**Right of Light Consulting**  
Burley House  
15-17 High Street  
Rayleigh  
Essex  
SS6 7EW

13 July 2023

**Application Reference No. 2023/62/91491/W**  
**Proposed Development at Prickleden Mills, Woodhead Road, Holmfirth, HD9 2JU**  
**Impact on 29 Woodhead Road, Homefirth, HD9 2JU**

**PROPOSED SITE SECTIONS SHEET 1 OF 2**

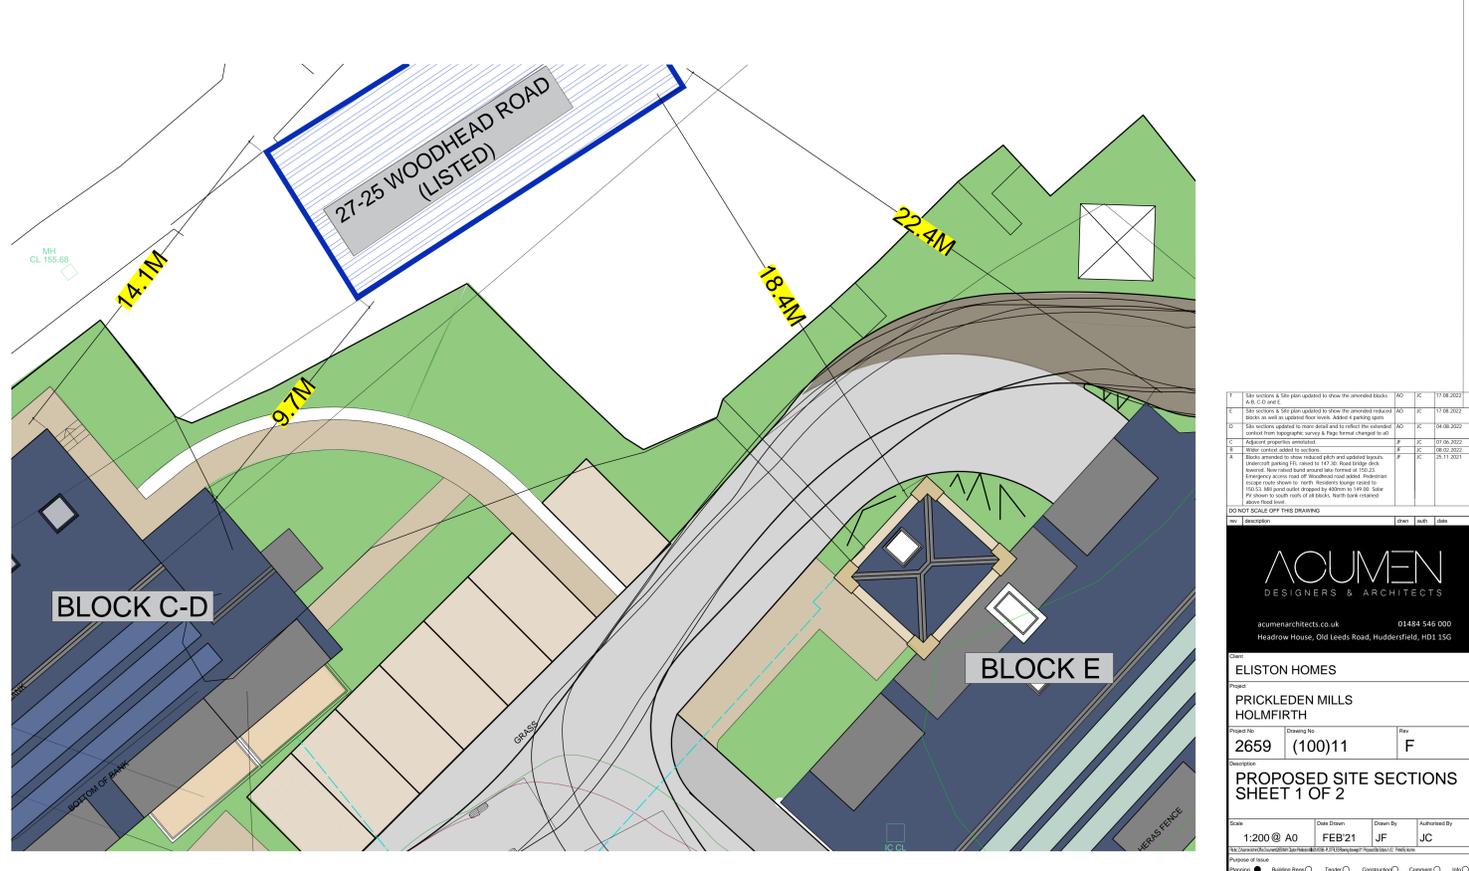
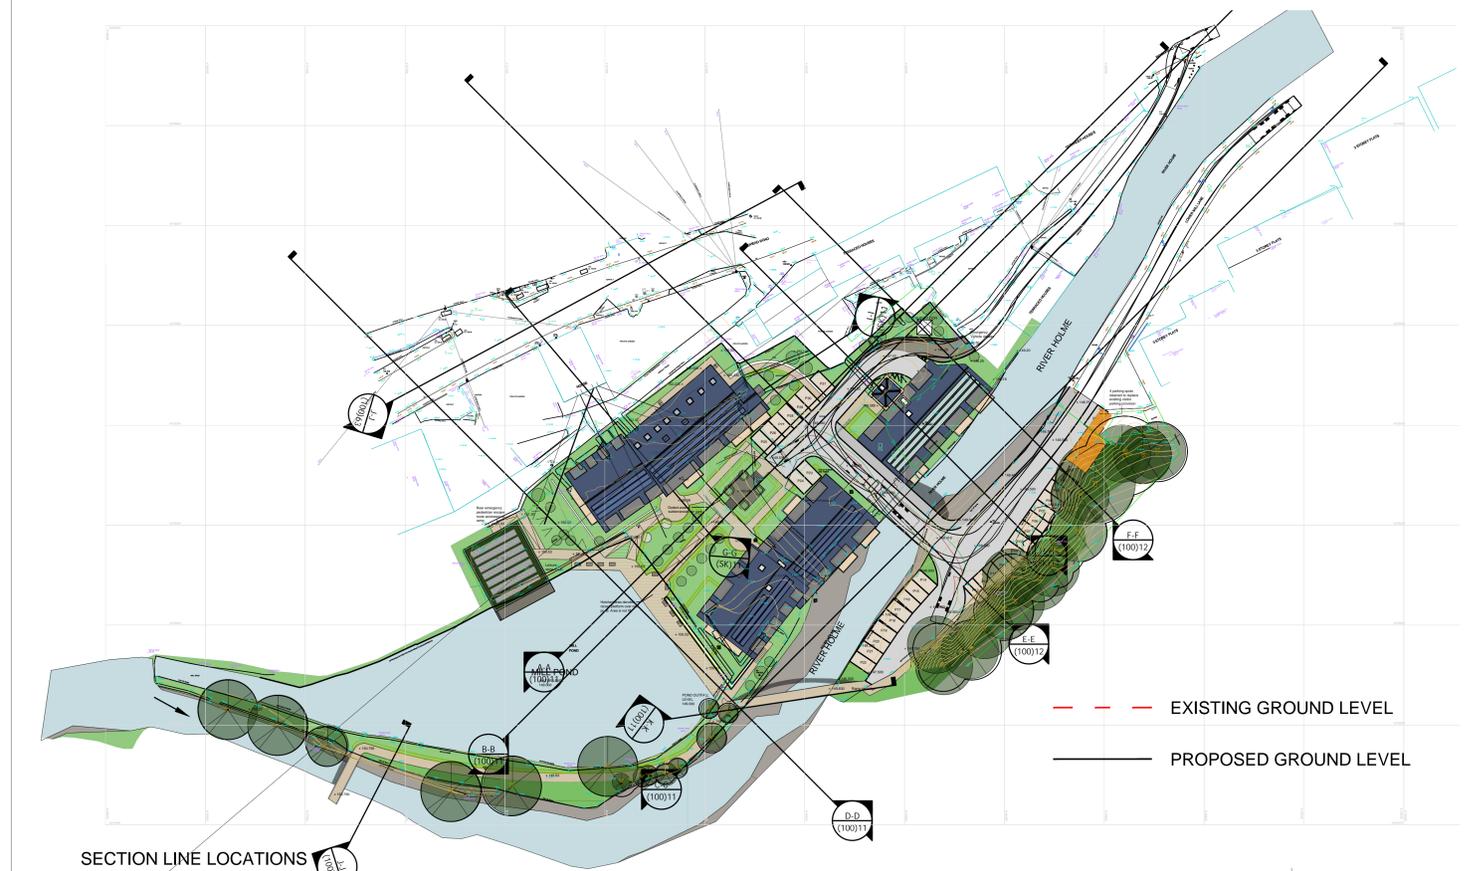
The application drawings for the proposed development at Prickleden Mills partially show the relationship to the living room windows at . We have plotted the approximate position of the centre of the living room windows on the proposed elevation drawing contained within the applicant's Design and Access Statement.

It is evident from the drawing below that the proposed development does not satisfy the 25° test. The 25° angle, drawn in green, extends through an area of the proposed development at Prickleden Mills.

Breaching the preliminary 25° test signifies that further detailed tests are needed. We would therefore expect the council to require the applicant to carry out an assessment in accordance with the BRE guide.
